TOWN AND COUNTRY PLANNING (GENERAL PERMITTED DEVELOPMENT) ORDER 2015 PART 6
PRIOR NOTIFICATION OF AGRICULTURAL AND FORESTRY BUILDINGS AND ROADS

Proposal: Prior notification for proposed agricultural building under Part 6 Class A of the GDPO.

Location: Land to the East of Slaidburn Road, Waddington, BB7 3AA.

PROPOSED ELEVATIONS  
 (Sheet 1 of 2)

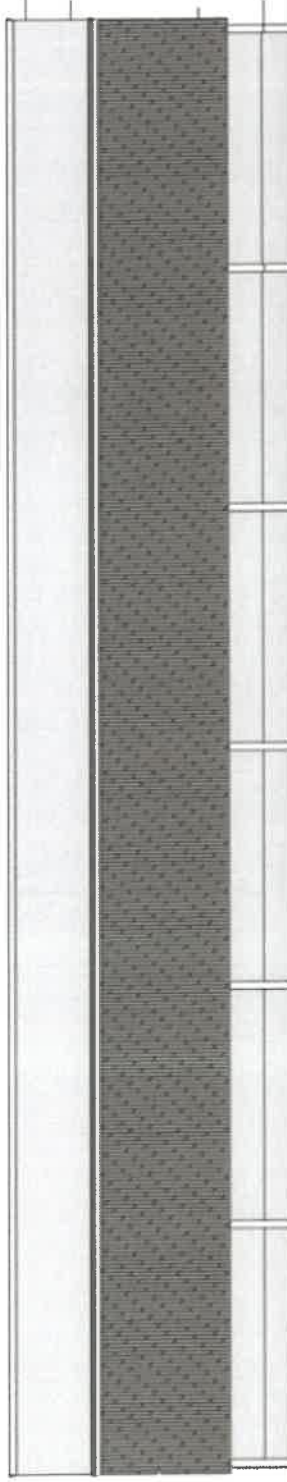
- 2 The proposed development, by virtue of its open and isolated siting, scale, visual prominence and location within a designated National Landscape is considered to be unacceptable in terms of its siting, design and external appearance. As such, the proposal fails to meet the requirements of Paragraphs 135 (c) and 189 of the National Planning Policy Framework and prior approval is refused on matters of siting and design.
